WEST SUSSEX COUNTY COUNCIL CONSULTATION

TO:	Arun District Council FAO: Mrs A Gardner
FROM:	Highways, WSCC
DATE:	15/06/2018
LOCATION:	Land adjacent to Pindars, Lyminster Road, Lyminster, BN17 7QF
SUBJECT:	LY/5/18/PL Erection of 1 No. two-bedroomed detached bungalow. This application is a Departure from the Development Plan.
DATE OF SITE VISIT:	
RECOMMENDATION:	☐ Advice ☐ Objection ☐ Modification ☐ No Objection ☒ More Information ☐ Refusal
S106 CONTRIBUTION TOTAL:	£N/A See below for breakdown.

DRAWING PLANNING DATE: JANUARY 2018 DRAWN: T. Murray	SCALE 1/50
DRAWING: 18/04/2	REVISION:

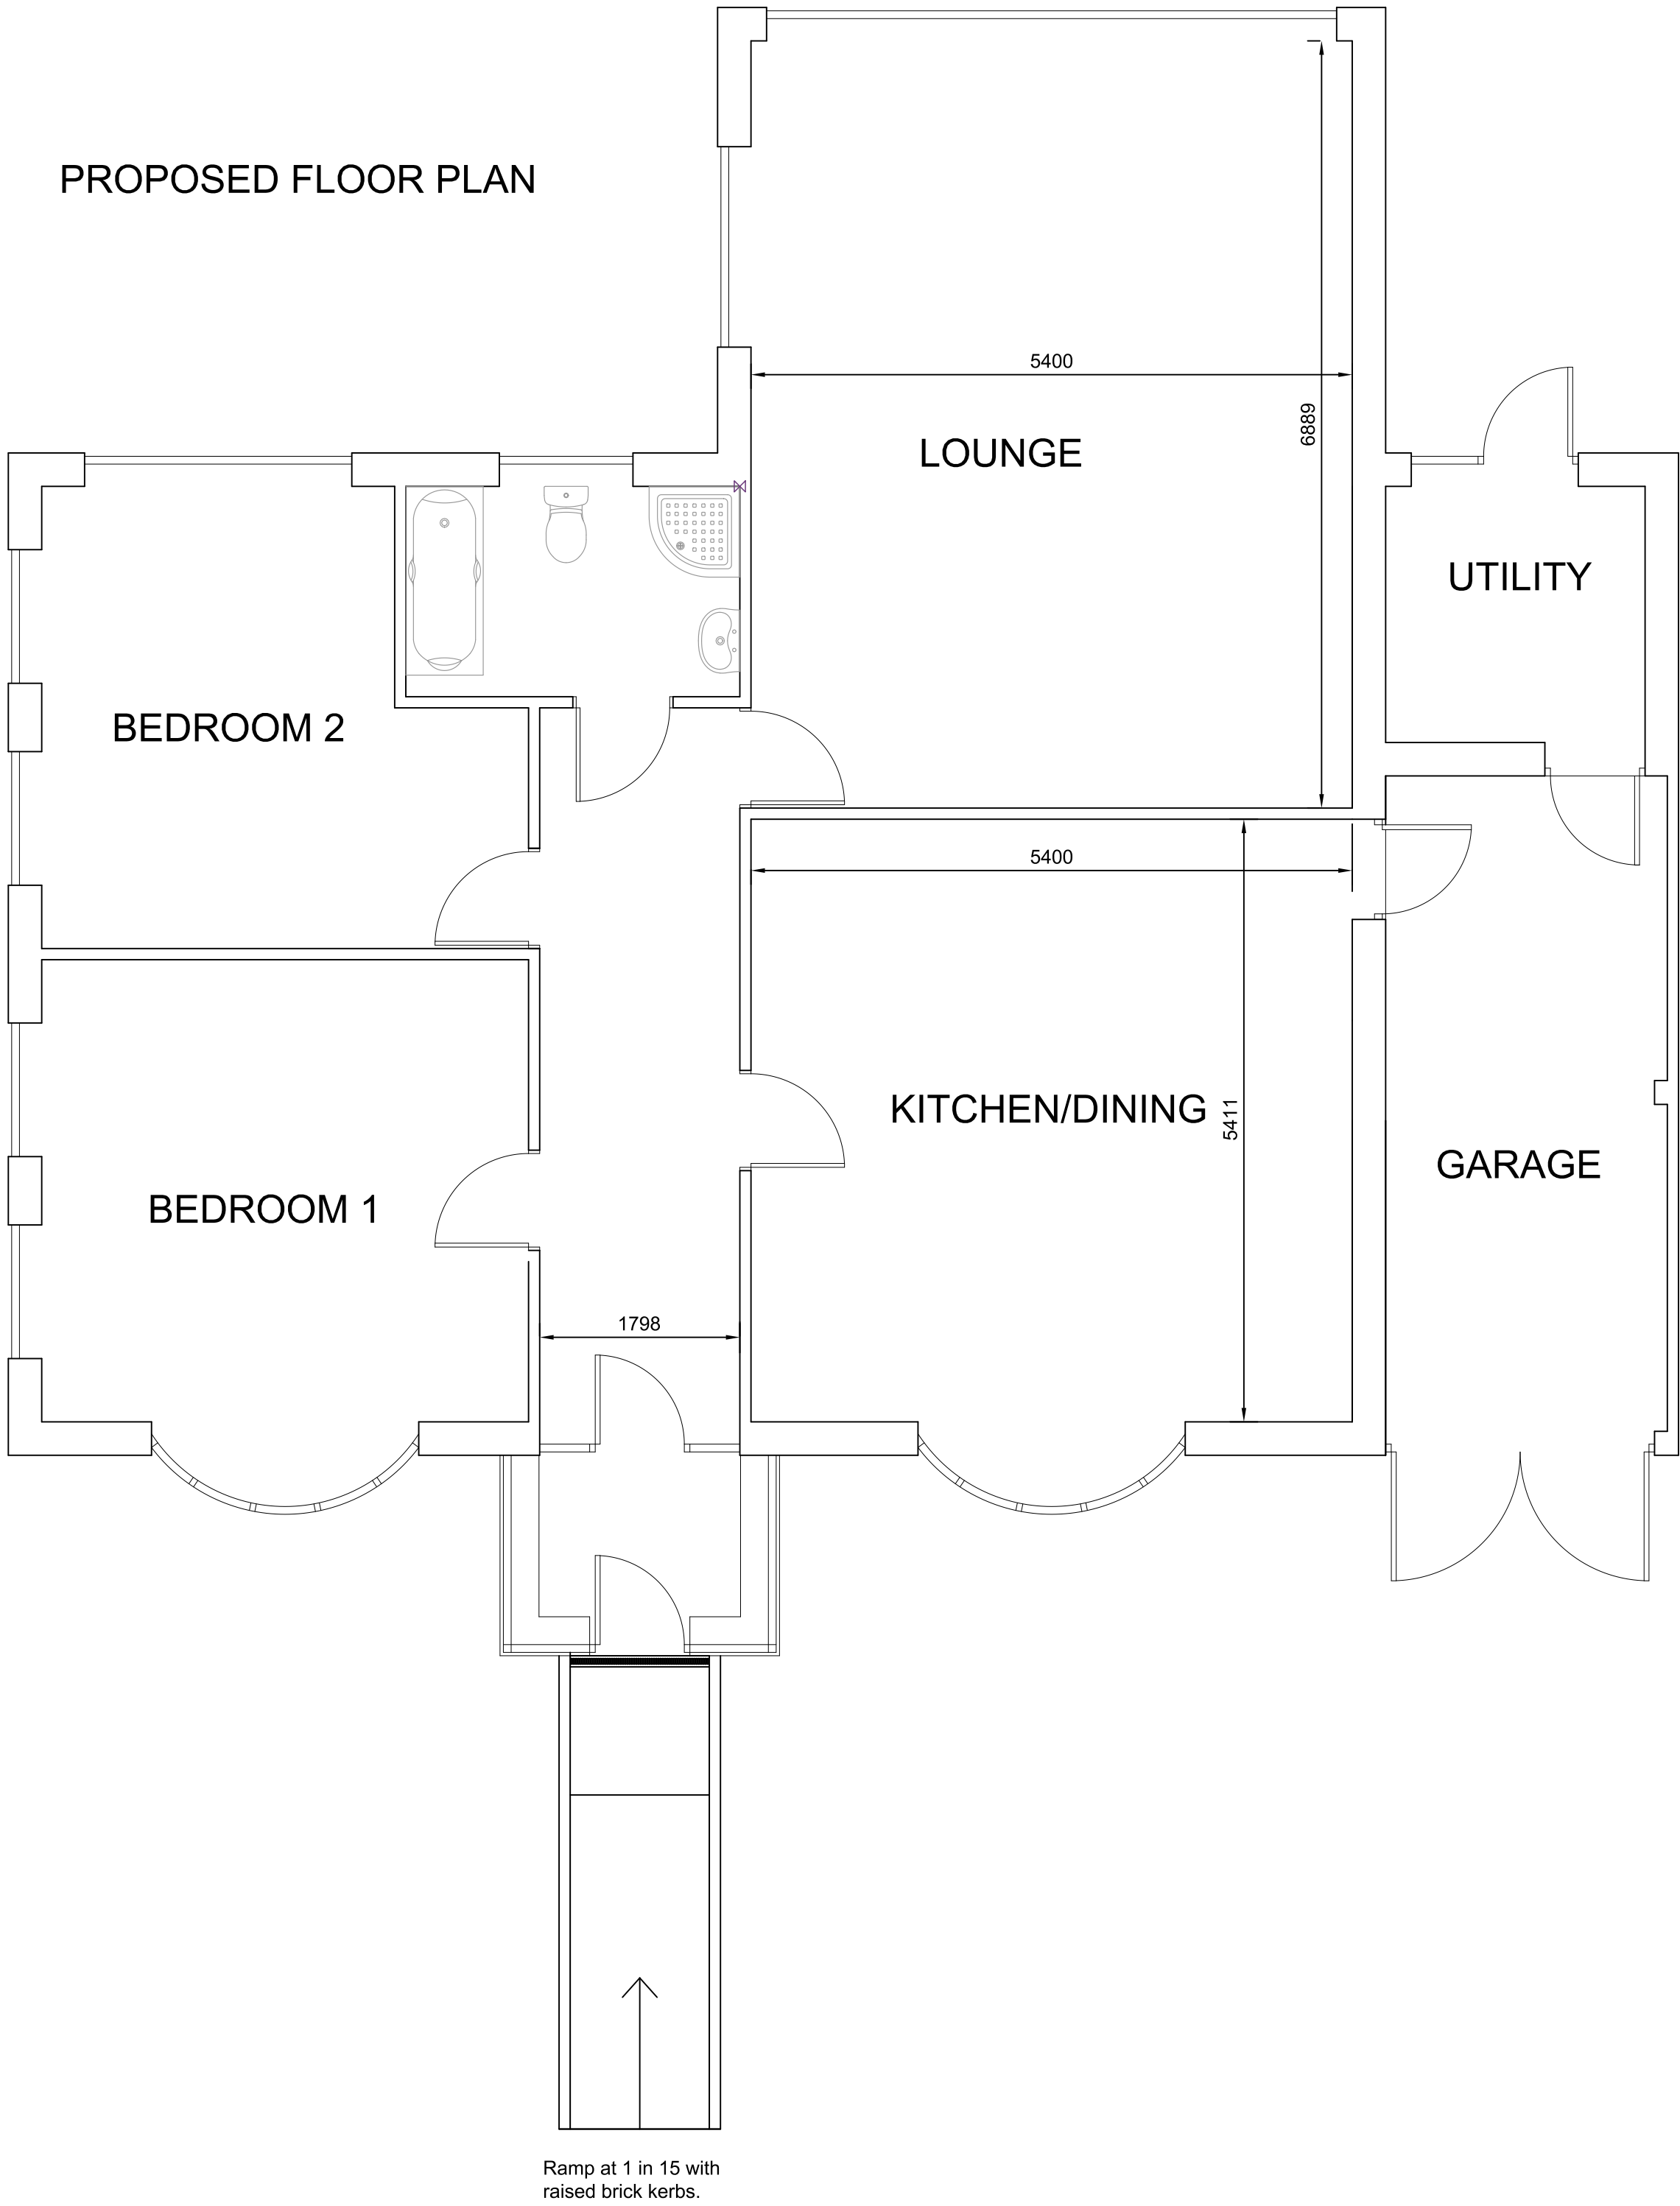
The integrated garage does not meet the minimum dimensions of 3m x 6m, as stated in Manual for Streets (MfS) and therefore cannot be counted towards parking provision. The two parking spaces shown on the frontage do meet the MfS minimum dimensions of a parking space of 2.4m x 4.8m. The WSCC car parking calculator would envision 2 car parking spaces for a house of this size in this location, which matches what the applicant has proposed.

DRAWING PROPOSED SITE PLAN DATE: JANUARY 2018 DRAWN: T. Murray	SCALE 1/500
DRAWING: 18/04/4	REVISION:

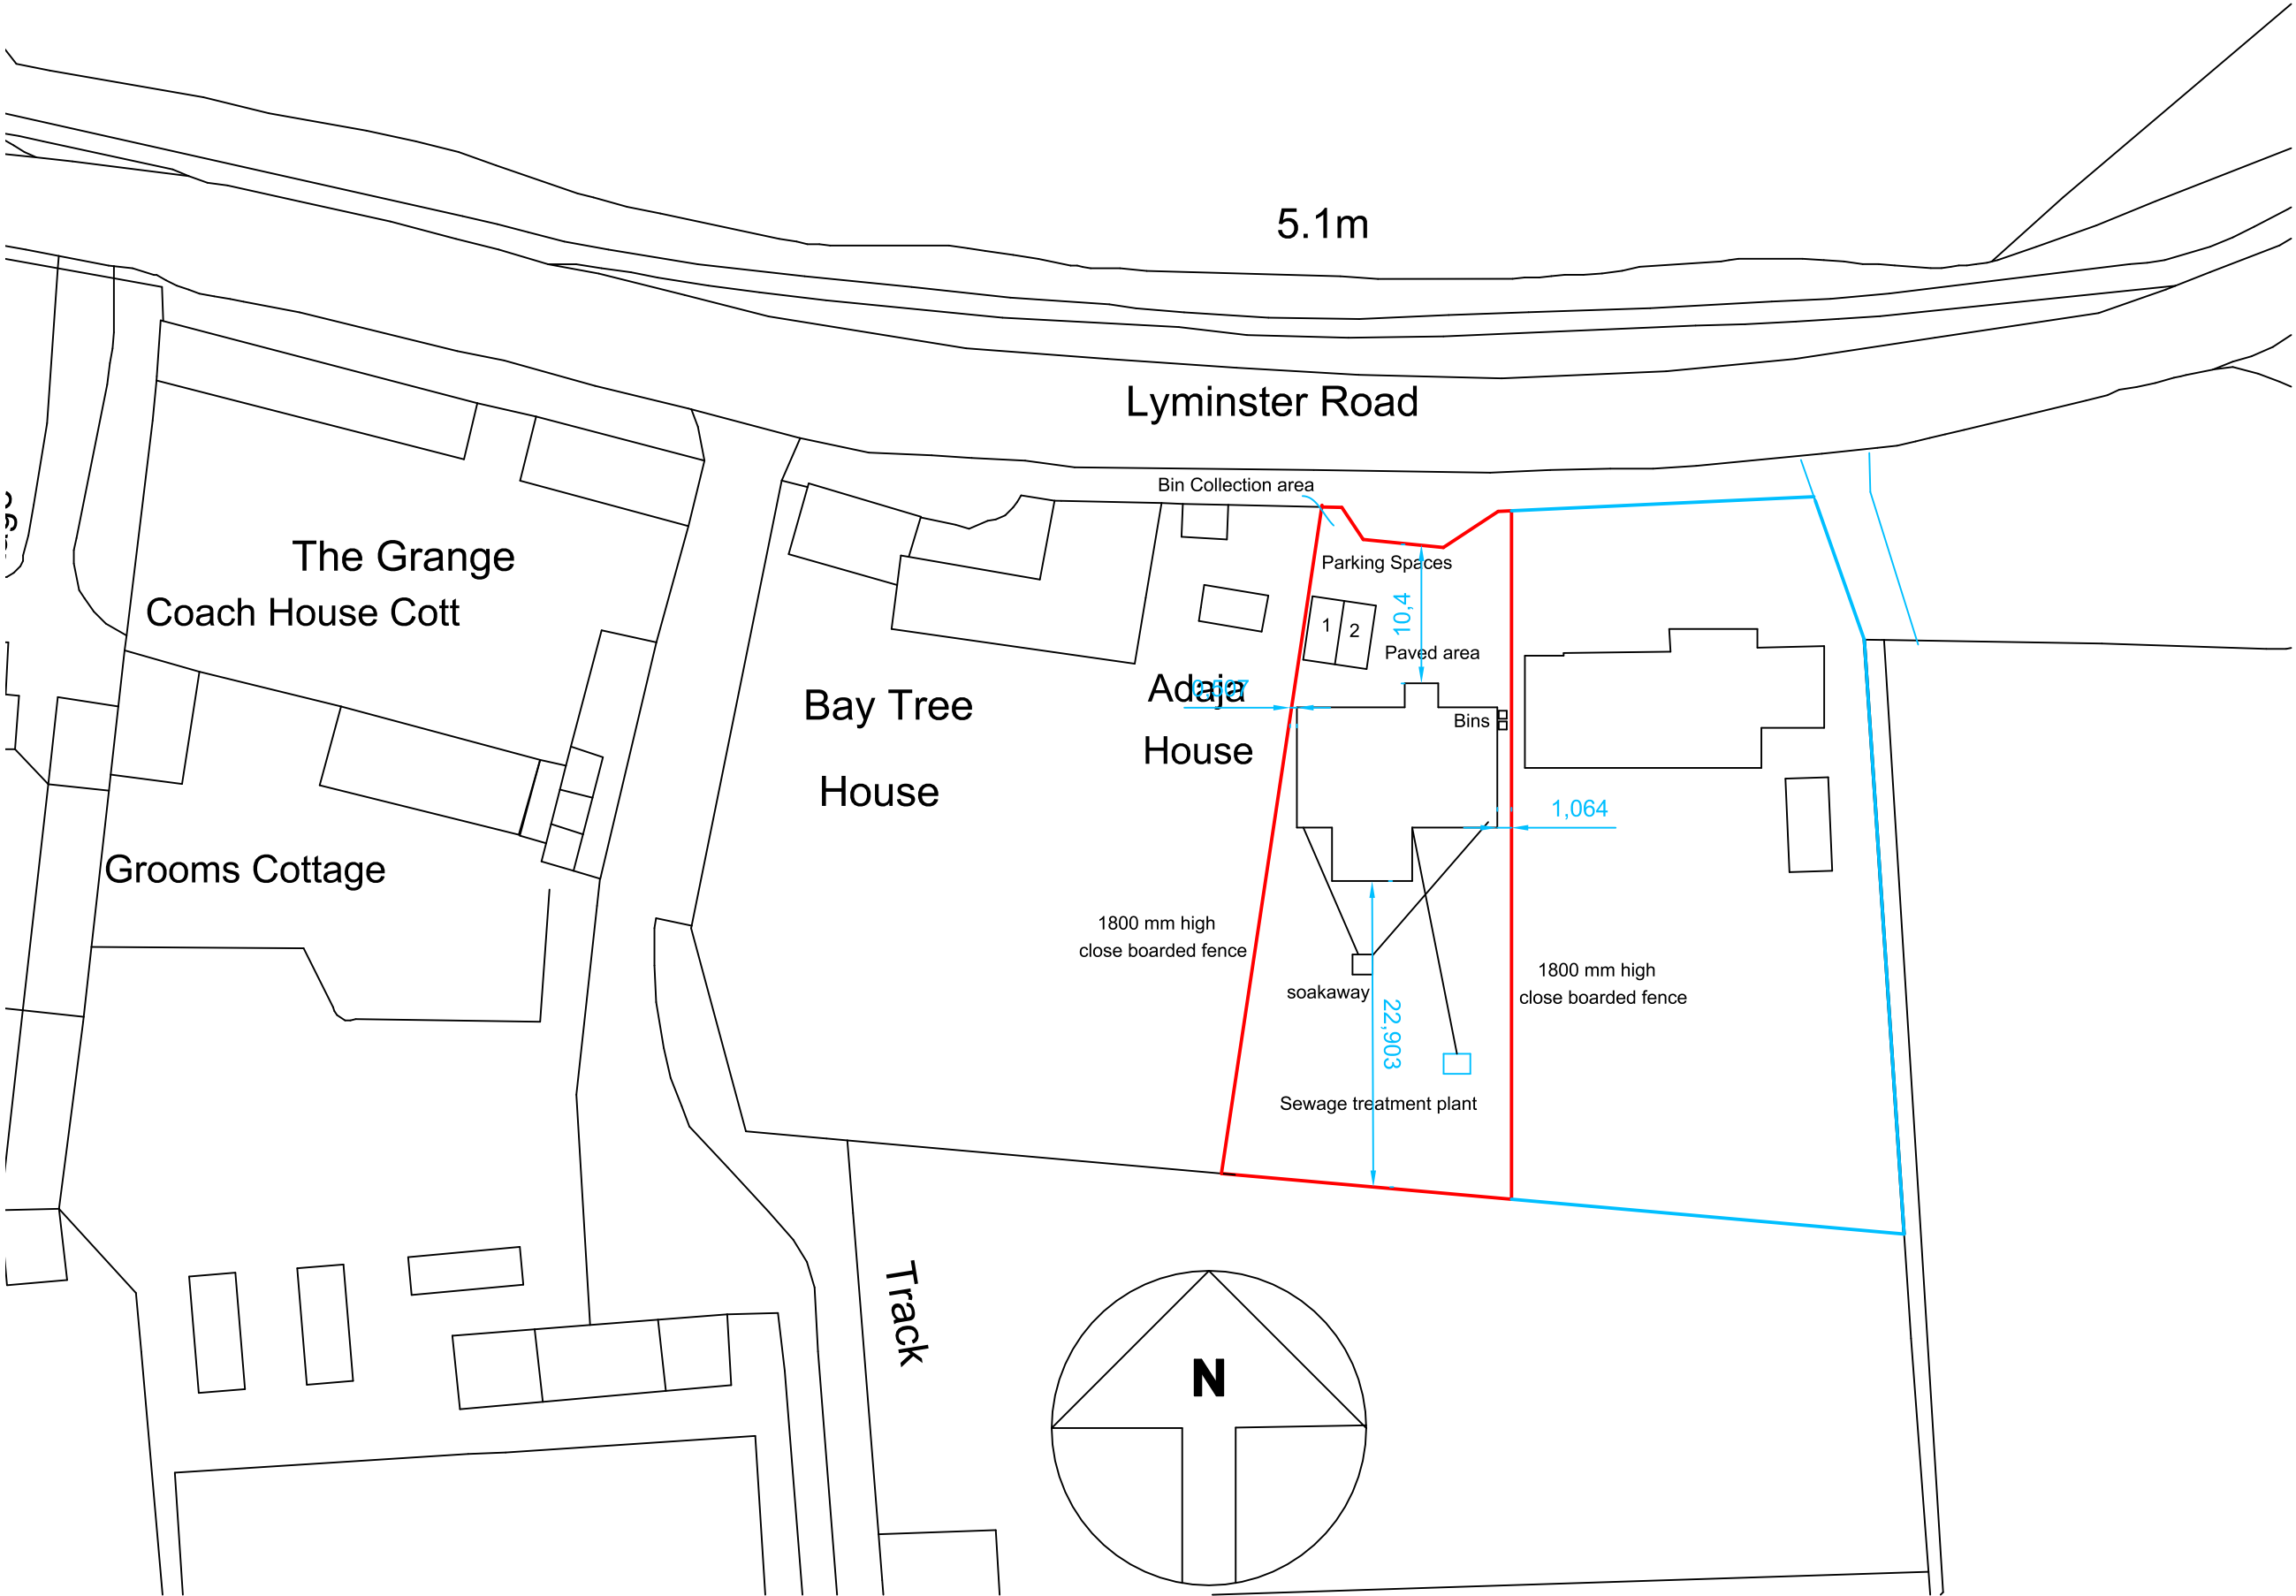
The applicant details that a 1.8m fence will be constructed at both the eastern and western boundaries of the site. It is unclear along how much of the boundaries the fence shall run. The LHA would advise that the applicant make clear the length and location of the boundary fence. If the fence is to go up to the edge of the highway, the LHA would suggest that the height be reduced to 0.6m to avoid obstructing the access visibility splays.

Concerning the paved area on the frontage, the applicant has not made it clear what space is to be used as a turning area to allow for cars to exit the site in a forward gear. The LHA request that the applicant make clear what section of the paved area will be allocated for a turning area and what is allocated as driveway access to the existing dwelling. The applicant should also consider whether there is adequate space for a vehicle to wait off the highway while a second vehicle is turning or exiting to ensure that the highway is not obstructed by a waiting vehicle.

The applicant should provide a plan showing a vehicle turning with space for a second vehicle to wait off the highway, mark the separate turning and driveway sections of the frontage of the proposed dwelling and detail the extent of the proposed fence, then re-consult with the LHA.
